**DELEGATED DECISION FOR APPLICATION FOR CERTIFICATE OF
LAWFUL DEVELOPMENT**

Reference no.: 2025/CL/93144/W

Site: 38, Oakes Lane, Brockholes, Holmfirth, HD9 7AR

Description: Certificate of lawfulness for proposed erection of rear dormer and associated alterations

Proposed Elevations & Sections DCC-16_0211

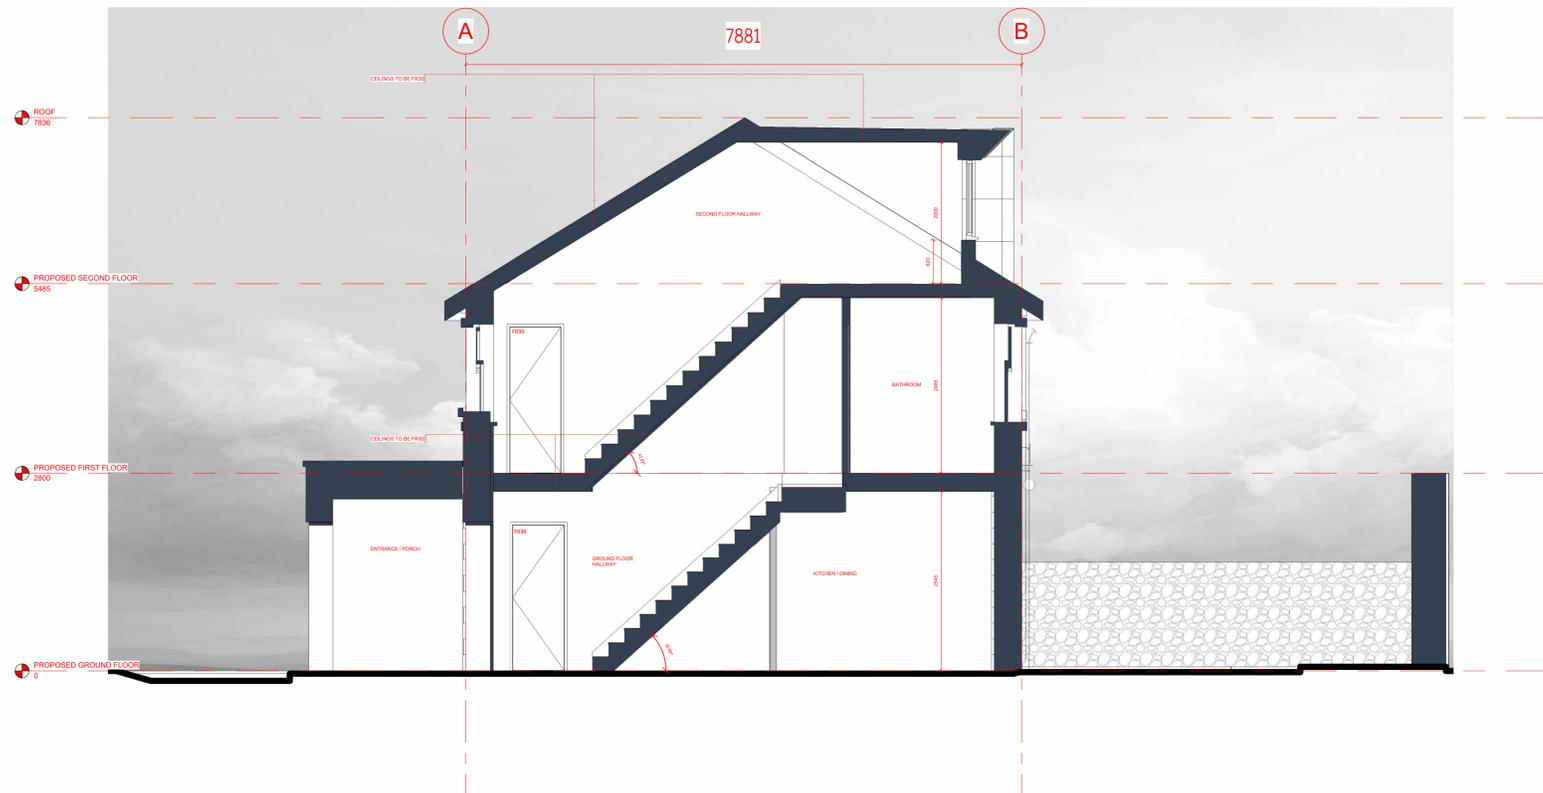
A dormer is proposed on the rear elevation, set back from the existing eaves by approximately 0.5 metres being a width of 4.9 metres. The dormer would project 3.9 metres from the roof ridge and would be a total height of 2.3 metres. The total cubic volume increase would be approximately 21.9 cm³.

It is important to note that the property has benefitted from a two storey side extension which has already increased the roof space of the original building. The previous addition to the roof had dimensions shown on approved plan 2003/91755, albeit slightly different to the plans submitted with the proposed dormer. The measurements on the 2003 plan are approximately 12.5% less than the measurements on the submitted drawings. Any re-submission may need to clarify the accuracy of plans This enlargement can be broken down into two additional shapes; one is essentially an irregular square based pyramid above the two storey extension which as a volume of $(1/3) \times \text{base area} \times \text{height}$ and a hip to gable enlargement of the original roof space which is essentially an irregular triangular based pyramid which as a volume of $(1/3) \times \text{base area} \times \text{height}$ much the same as a hip to gable enlargement..

Therefore, the total roof enlargement with the dormer would be 52.7m³.

Comment: *The cubic content of the resulting roof space would exceed 50 cubic metres due to the construction of the 2 storey side extension which was granted permission under application number 2003/91755. The proposed additional and proposed roof space would exceed 50 cubic metres.*

The proposed rear dormer extension as shown on the submitted plans listed in this decision notice does not benefit from a general planning permission granted under Article 3(1) and Schedule 2, Part 1 (Development within the curtilage of a dwelling house), Class B of the Town and Country Planning (General Permitted Development)(England) Order 2015 (as amended) as the proposal exceeds the resultant roof space limitation as set out in sub-paragraph B.1(d) and B.3 of Class B.
